SECURITY FIRE STATION NO. 4

SITE DEVELOPMENT PLAN SITE PLAN

DP-2 MVE PROJECT 61134
MVE DRAWING DEV-SP

PCD FILE # PPR-20-029

SITE DEVELOPMENT PLAN
 SITE PLAN

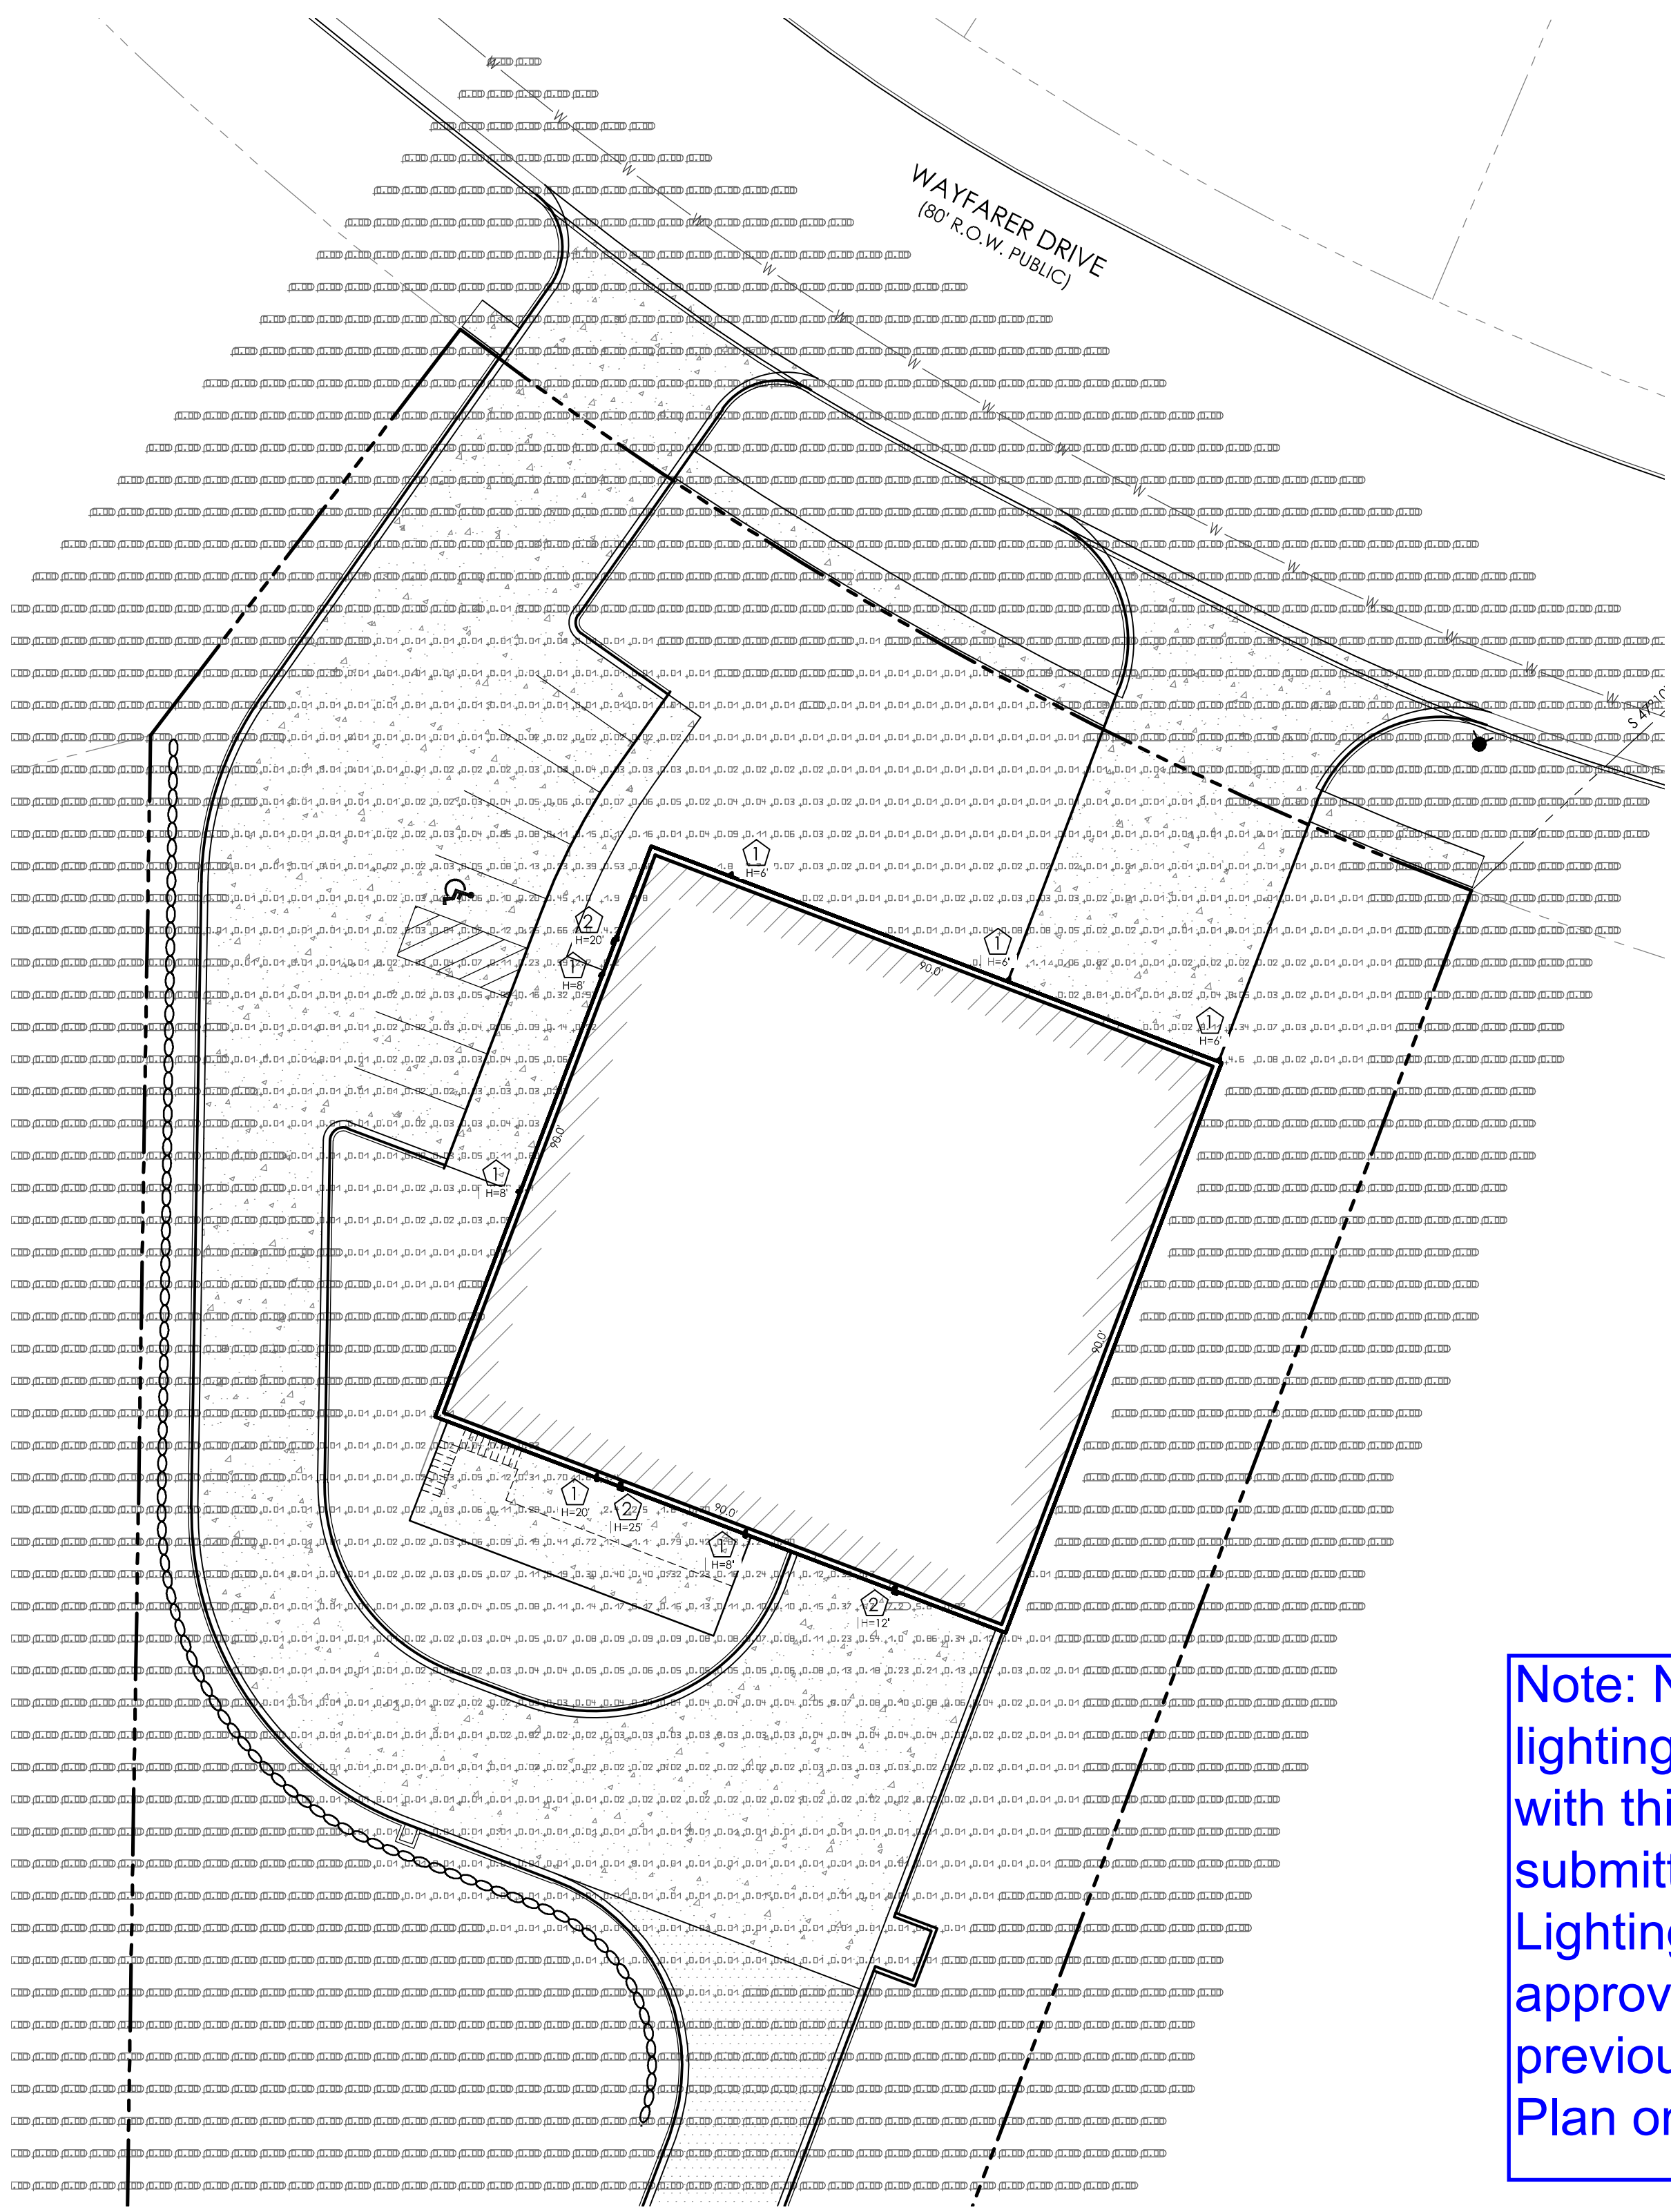
- Provide contours for site plan in areas where grading will occur.
- Provide spot elevations on new parking areas.
- Update site plan to show existing and proposed items to avoid confusion with what is already constructed on the site.

If fencing is 7ft or more, a building permit is required
Section 6.2.1.D
